From: [REDACTED]  
To: [REDACTED]  
Subject: DCO  
Date: 14 June 2019 19:15:57  
Attachments: [RSP 18.pdf](#)

# Noise contours commissioned from the Civil Aviation Authority by No Night Flights

## NNF18

Figure 12.9
Aircraft noise - night-time L_{ASmax}
contours - year of forecast maximum
capacity

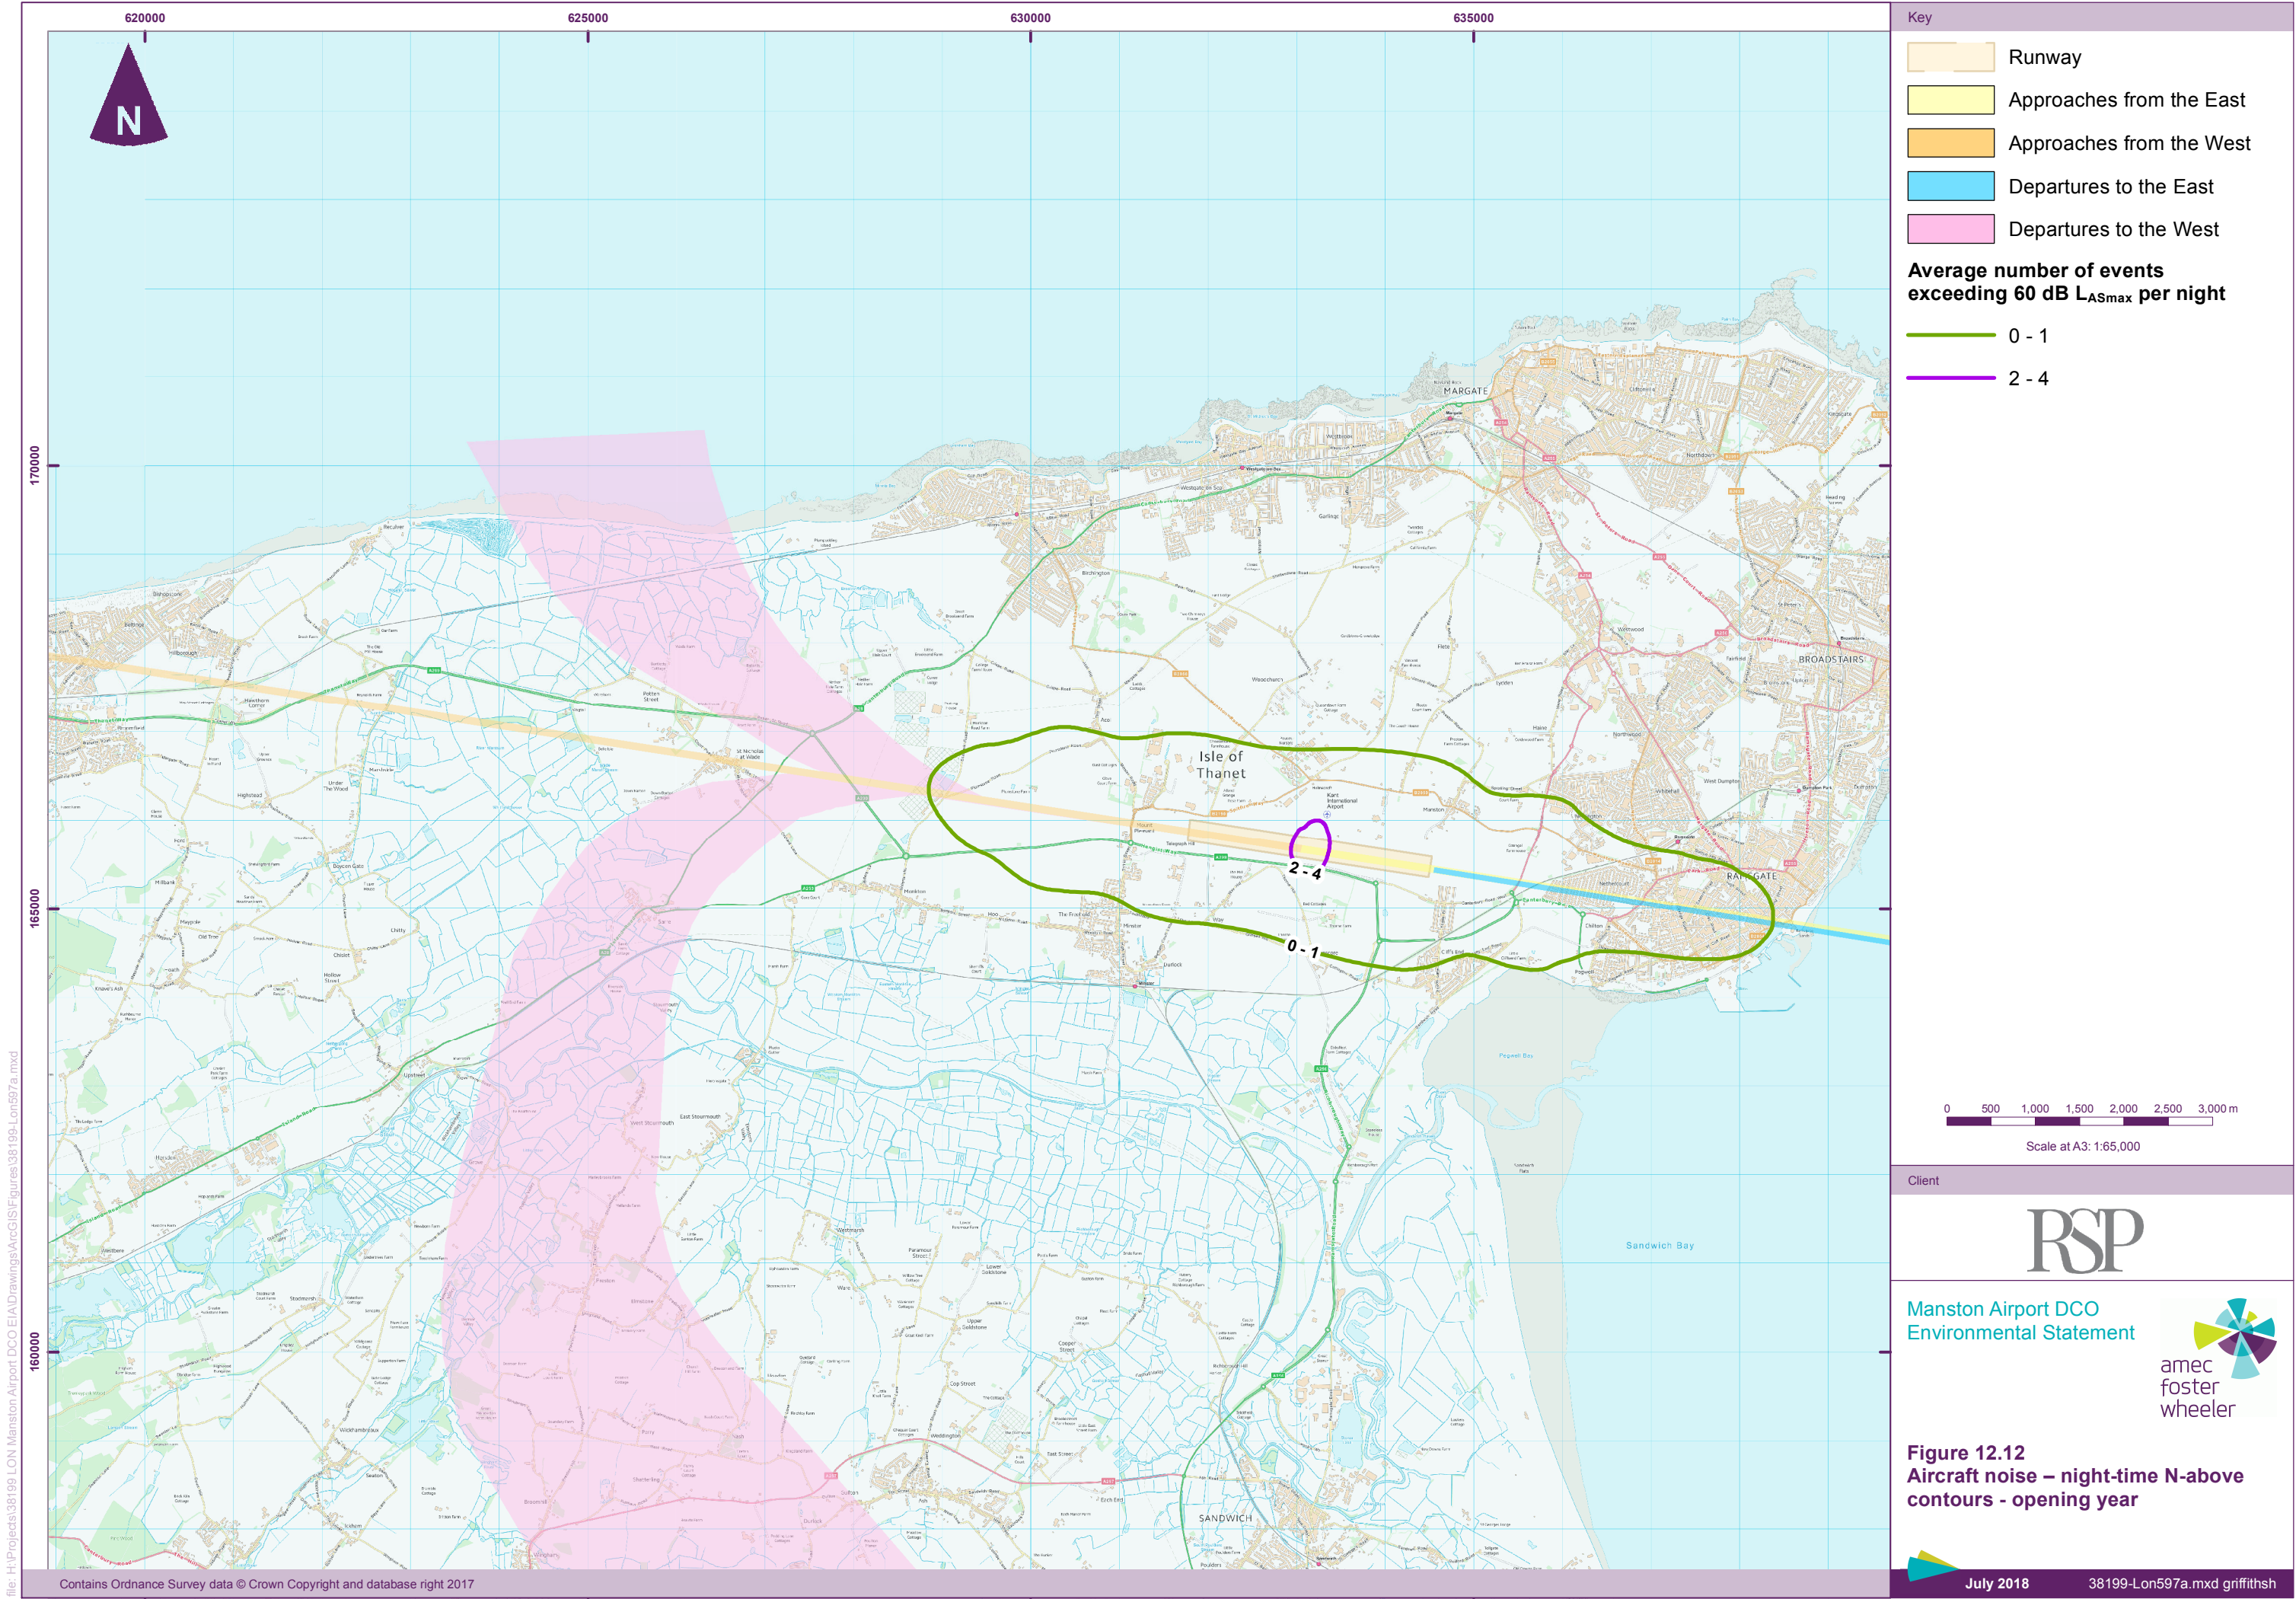
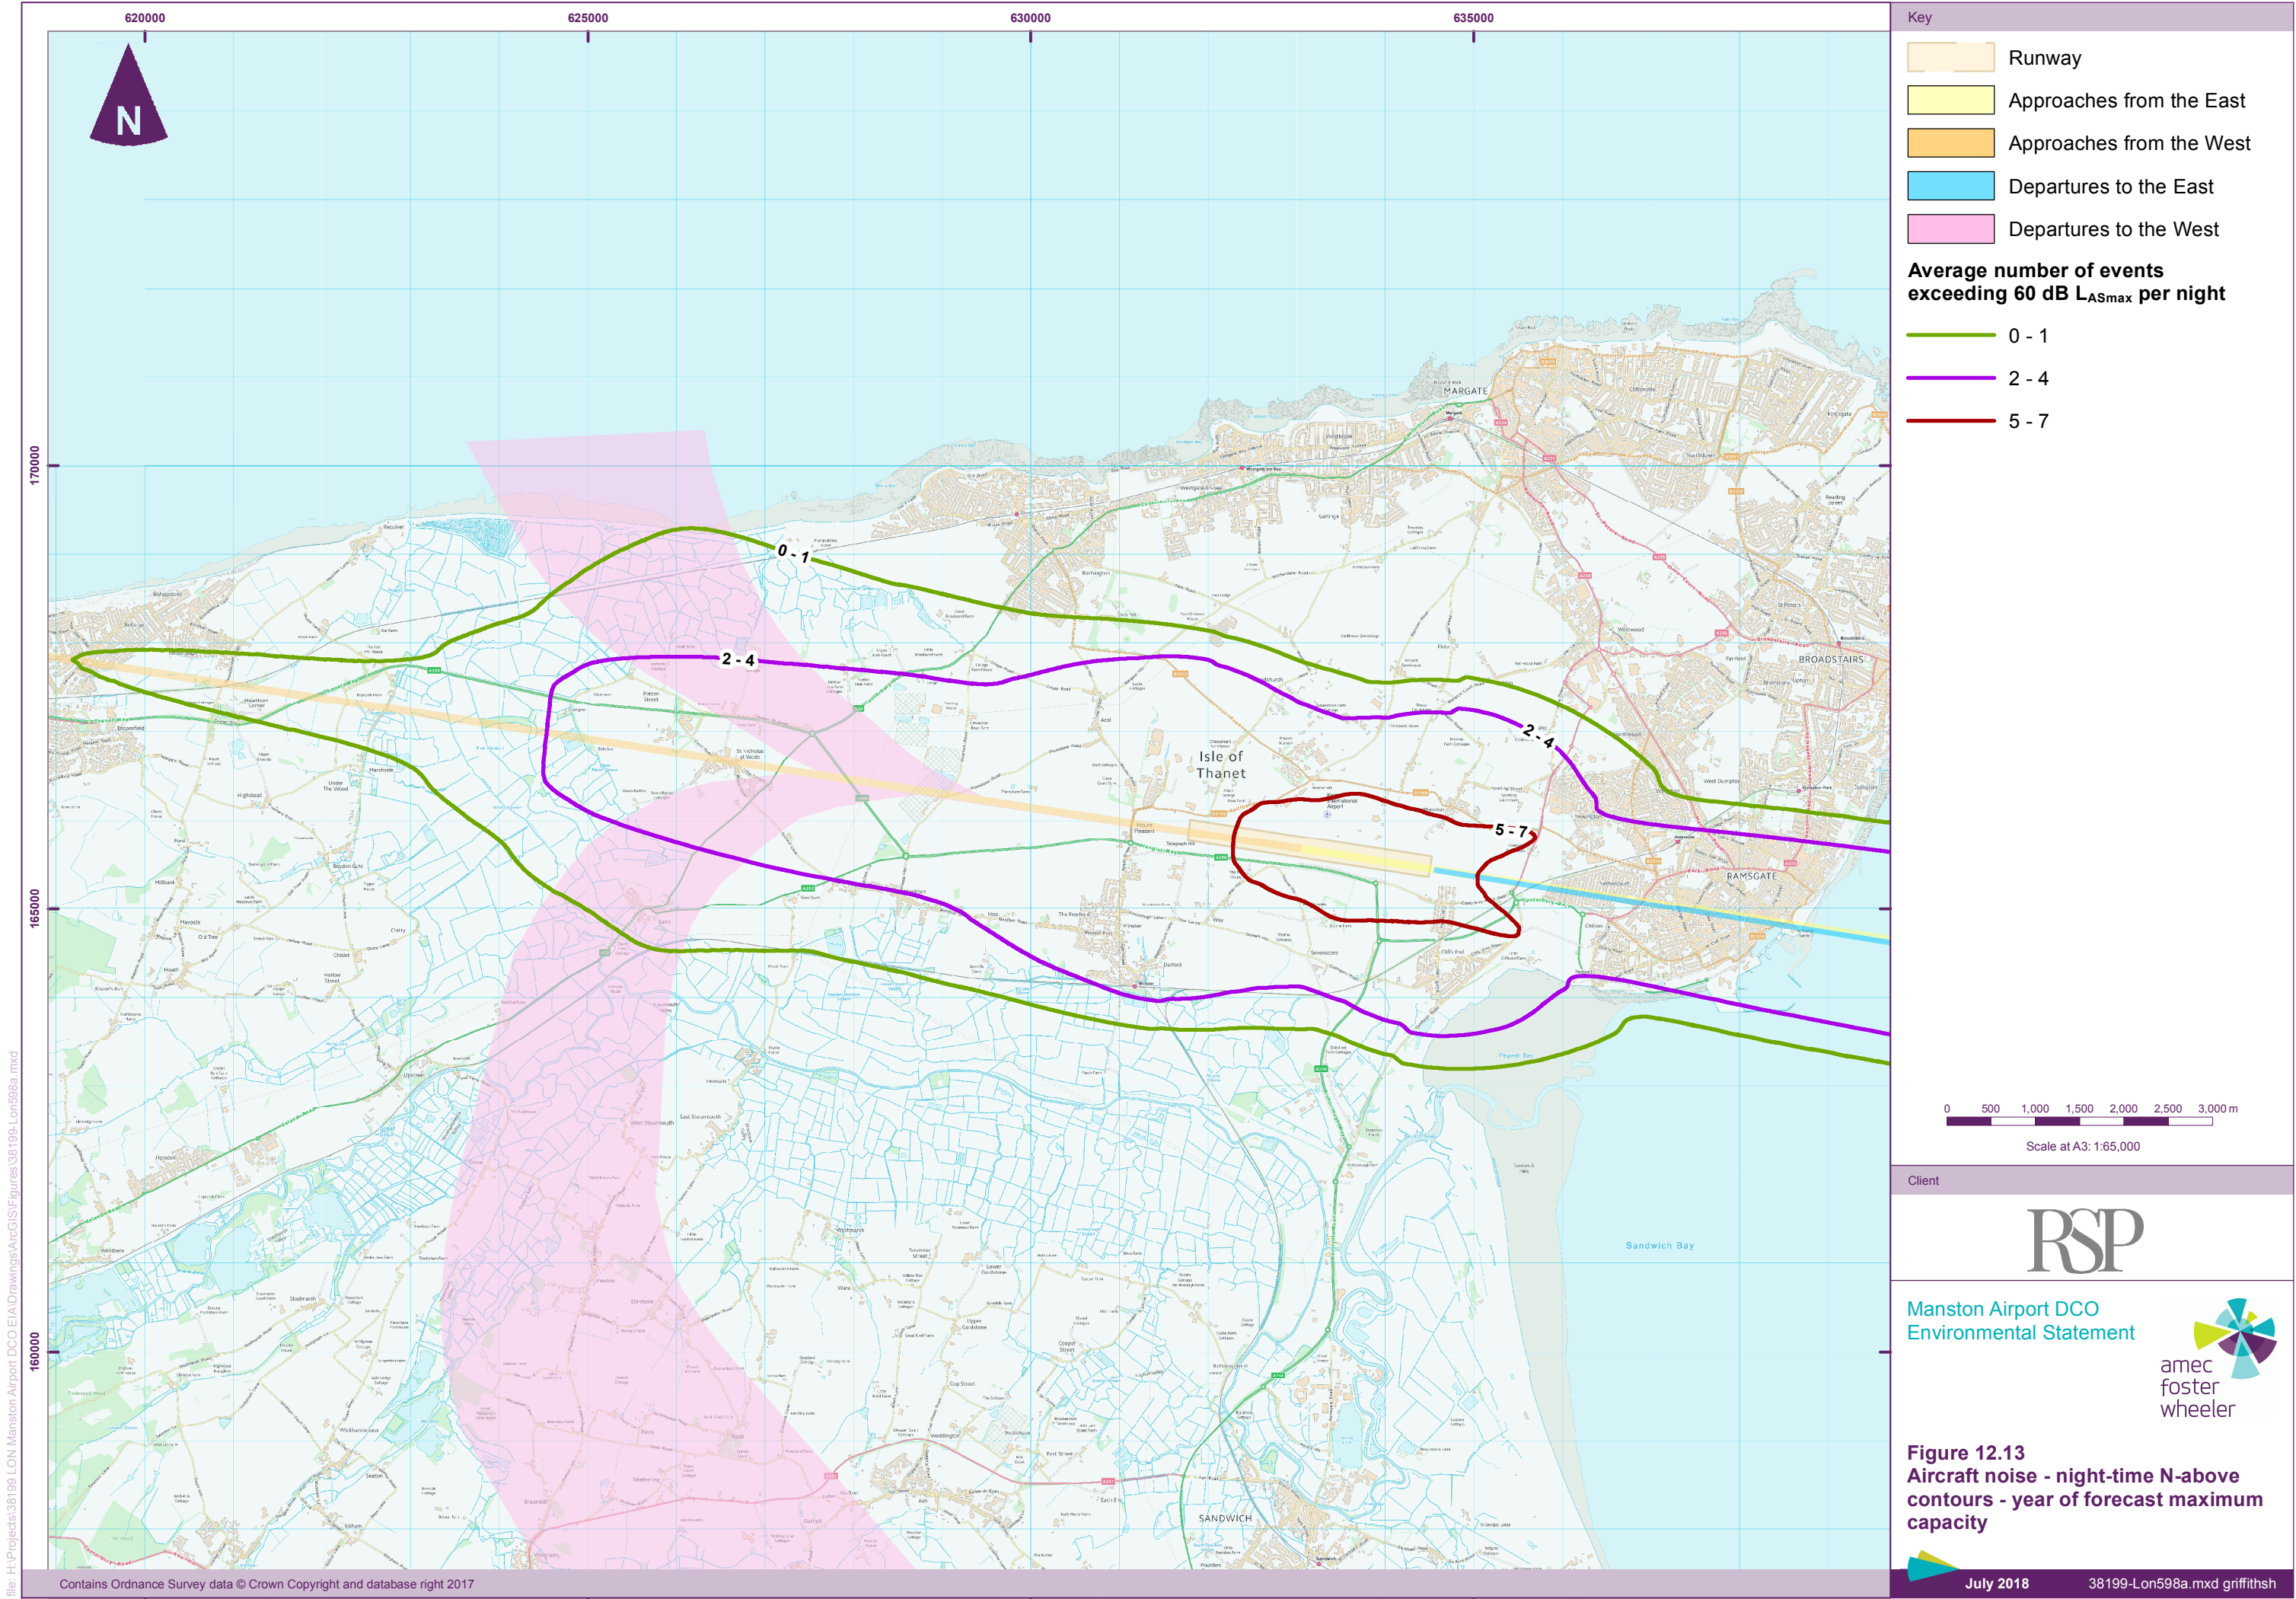
55. It is hard to compare the CAA's noise contours with those provided by RSP. As far as we can tell (it is needlessly difficult to navigate RSP's thousands of pages of unhelpfully referenced submissions, so we may have missed something), RSP has failed to model the noise impact generated by a single 747-400 flight on each of the five available routes. The nearest comparators that we can find are RSP's LASmax night contours for Year 20.<sup>10</sup>

56. A comparison of RSP's Figure 12.9 (page 63) with NNF's Maps 1 and 2 reveals a significant noise impact that RSP has simply not shown. The 70dB contours extend over the entire town of Herne Bay in the NNF contours. RSP has only modelled 80dB LASmax and so Herne Bay does not even appear on its maps. This suggests that Herne Bay will be entirely unaffected by aircraft noise – an assertion often made by the RSP team at various consultation events. However, Herne Bay residents know from experience that a single 747-400 creates a significant noise footprint. A 747-400 overflying Herne Bay in the daytime is loud enough to make people look up as it goes over. At night, the impact is greater. The real impact on Herne Bay residents is entirely missing from RSP's assessment of noise impact.
